EP-24-0022_3 Overlook at Homestead Filing No. 1 Final Plat
File Number: SF2425
Location: Section 27, T11S, R64W, 6th P.M.
39.0681, -104.5456

The available referral documents include the Response to CGS Review Comments (Entech Engineering, Inc., November 13, 2024), a Soil and Geology Study (Entech Engineering Inc., Revised November 13, 2024), Final Plat (Edward-James Surveying, Inc., June 5, 2024), Letter of Intent (N.E.S., Inc., November 2024), Final Drainage Report (Kimley Horn and Associates, November 6, 2024), and other documents. We understand that Filing No. 1 comprises 36 single-family lots within 202 acres. Entech's response to our review comments generally addresses some of our previous comments. We offer the following comments.

Submitted 11/25/2024 by Amy Crandall, Engineering Geologist, Colorado Geological Survey (303-384-2632 or acrandall@mines.edu)

GEOLOGY/ENGINEERING MAP
 OVERLOOK AT HOMESTEAD, FILING NO. 1
 PT OVERLOOK, LLC

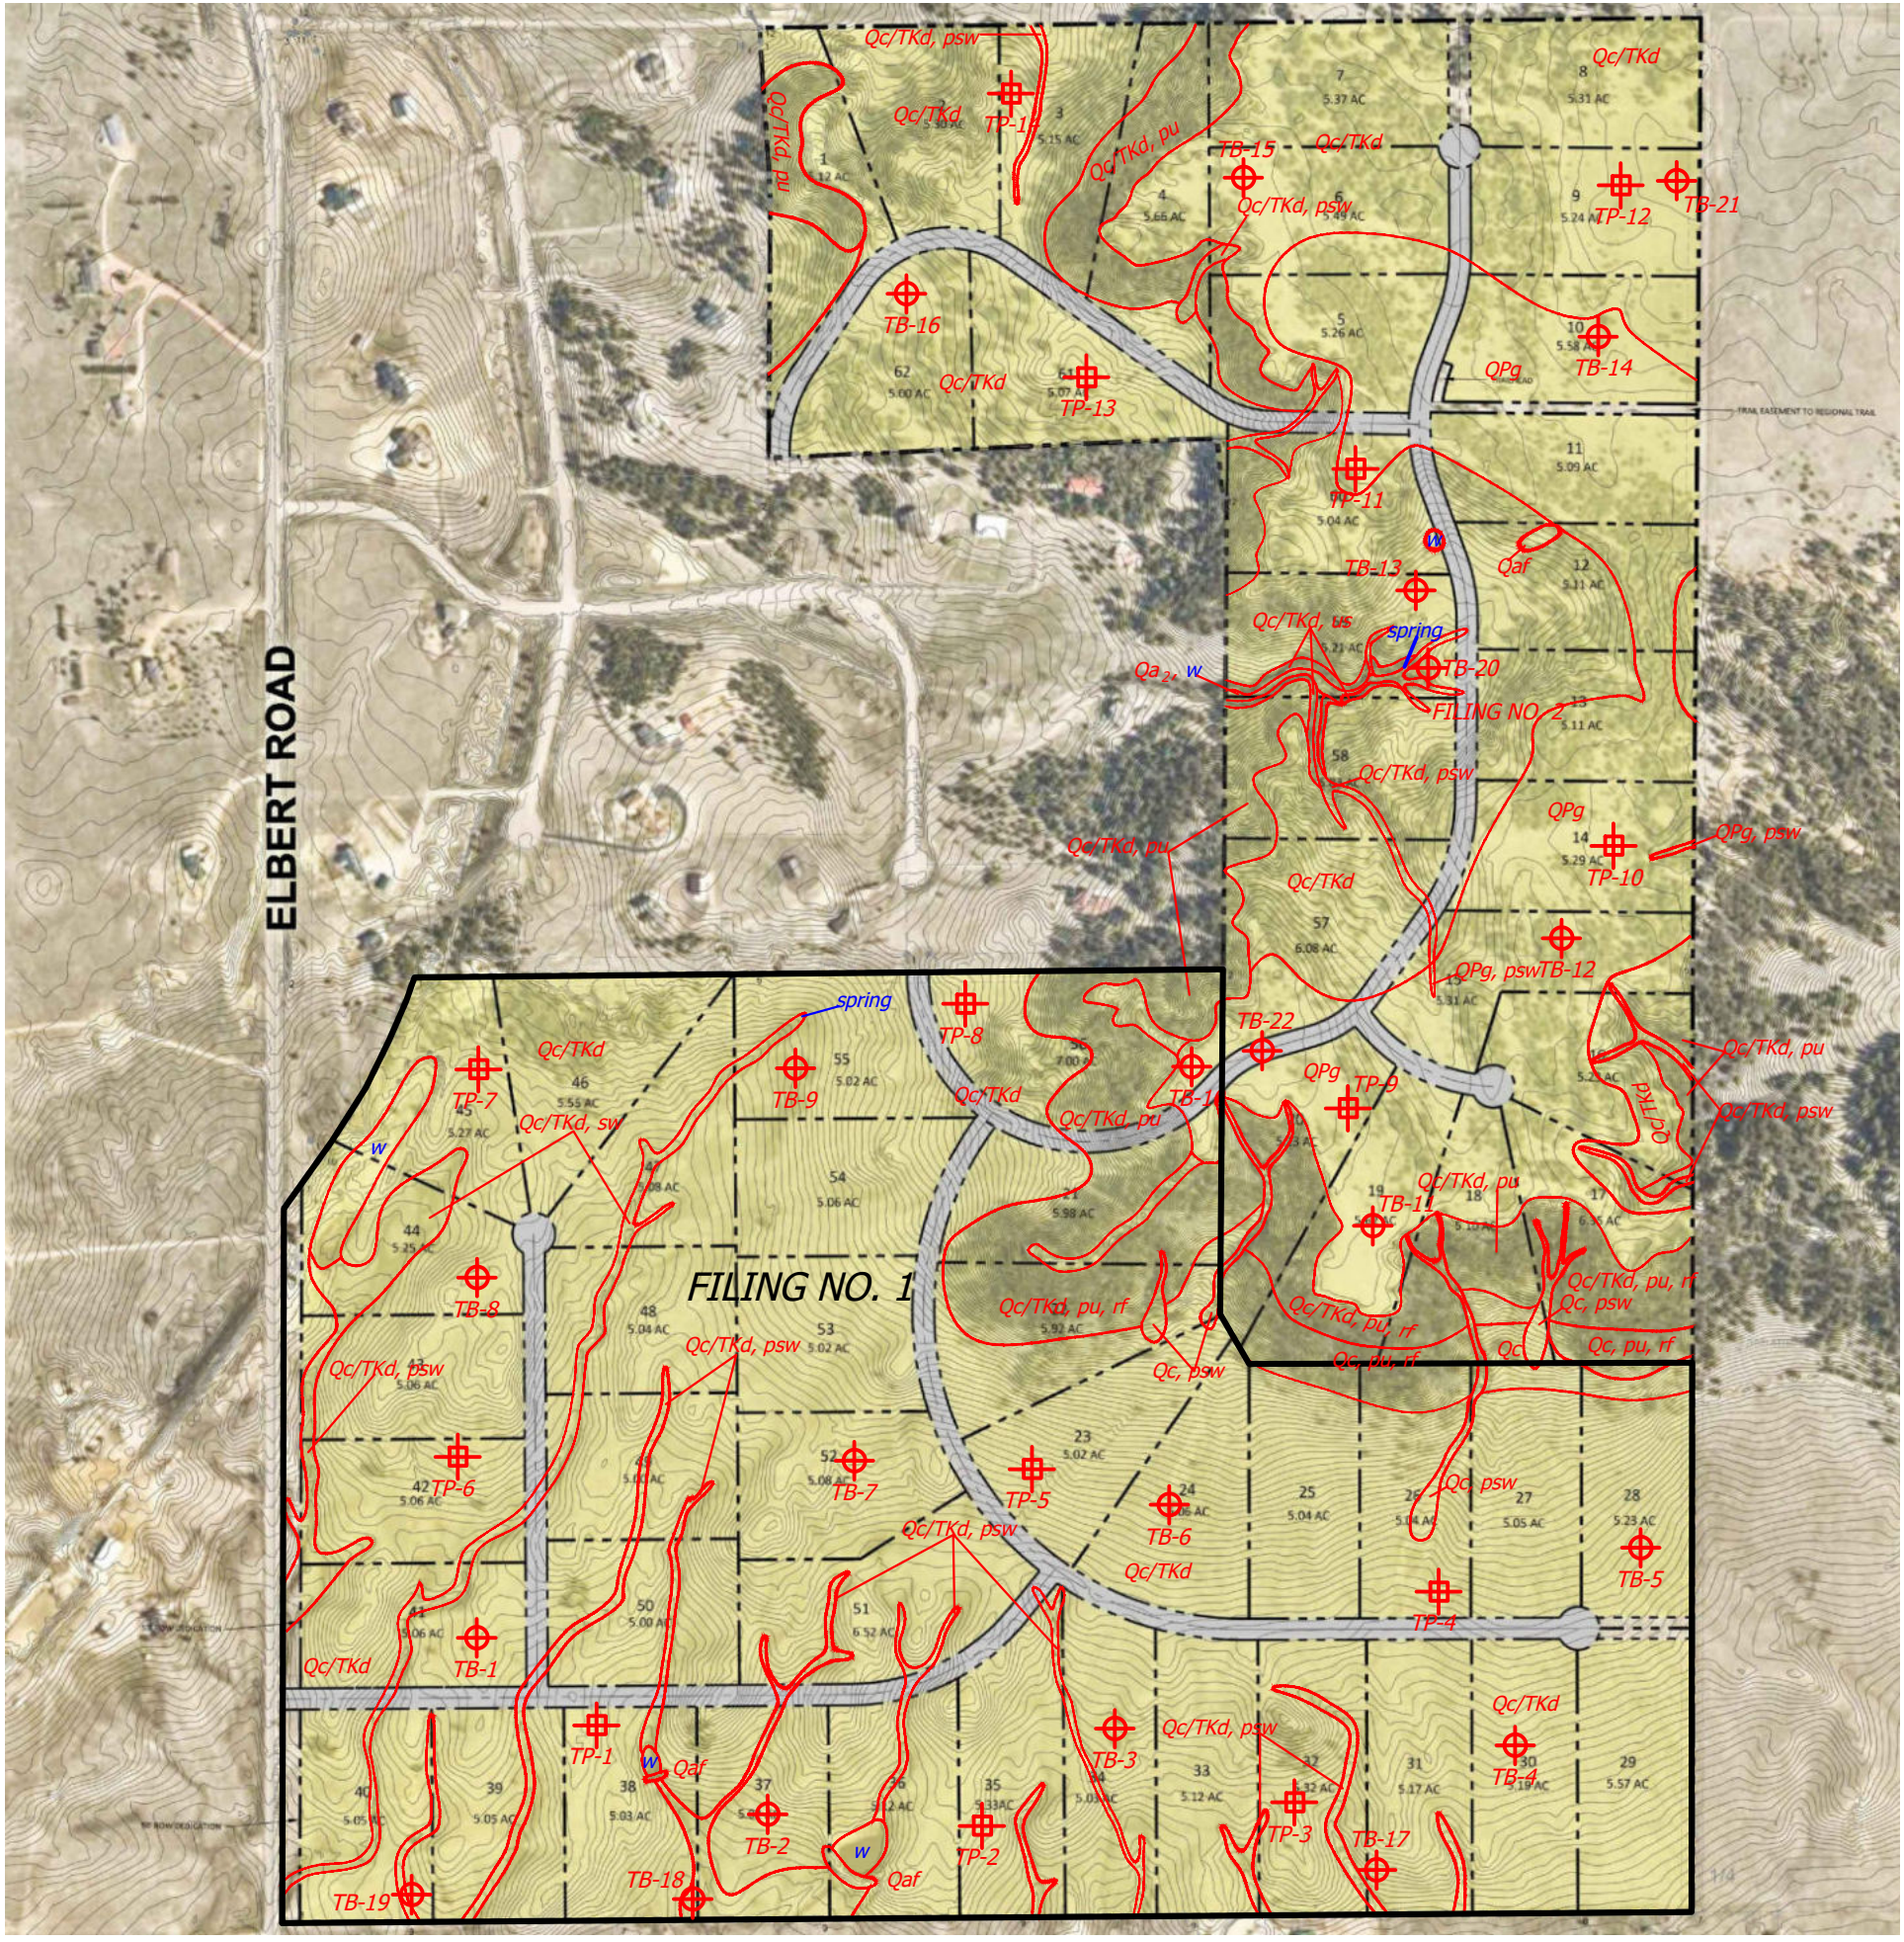
Rockfall and potentially unstable slopes. Entech identified potentially unstable slopes along the mesa with rockfall hazards associated with the rock outcrops. The lots listed on Entech's site plan have been updated to match the final plat (Edward-James Surveying, Inc., June 5, 2024). Entech states in their response letter, "Lots impacted by the Rockfall and Potentially Unstable Slopes within Filing No. 1 include Lots 18-26. These areas should be identified as no-build areas." **CGS recommends that Note 28 of the final plat is updated to include rockfall hazards associated with Lots 18 to 26 and "no-build areas" noted on the plat.** Site improvements must not be located within areas mapped with hazards/constraints.

Debris fans/debris flow susceptibility. The lots listed on Entech's site plan have been updated to match the final plat (Edward-James Surveying, Inc., June 5, 2024). Entech states in their response letter, "Lots impacted by the Debris Fan/Debris Flow Susceptibility includes Lots 11-23." However, Fig. 7 of their revised report states, "Debris Flow Susceptibility – (Figure 9) Lots affecting by this potential hazard include Lots 23-35." **CGS recommends that Fig. 7 of Entech's report and Note 28 of the final plat be updated to include debris flow hazards associated with Lots 11-23.**

**TYP. UNDERSLAB DRAINAGE LAYER
(CAPILLARY BREAK)**

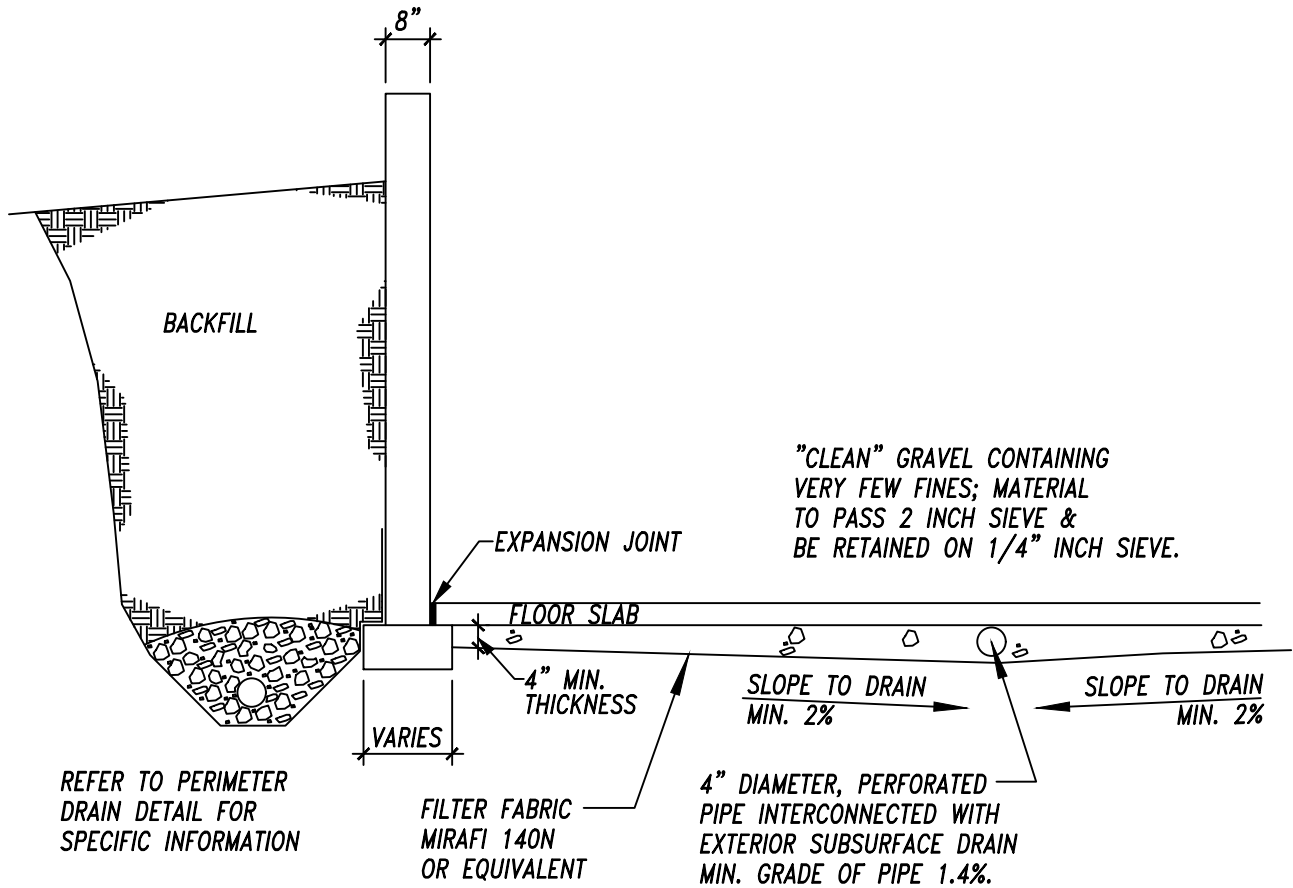
Entech states (p. 9), "Where shallow groundwater is encountered, underslab drains or interceptor drains may be necessary." An underdrain system should be allowed ONLY if it can gravity discharge to a daylight outfall. Additionally, Entech states, "In areas where high subsurface moisture conditions are anticipated periodically, a subsurface perimeter drain will be necessary to help prevent the intrusion of water into areas located below grade." Individual foundation perimeter drains are intended to handle small amounts of intermittent, perched water and may NOT be used to mitigate persistent shallow groundwater conditions.
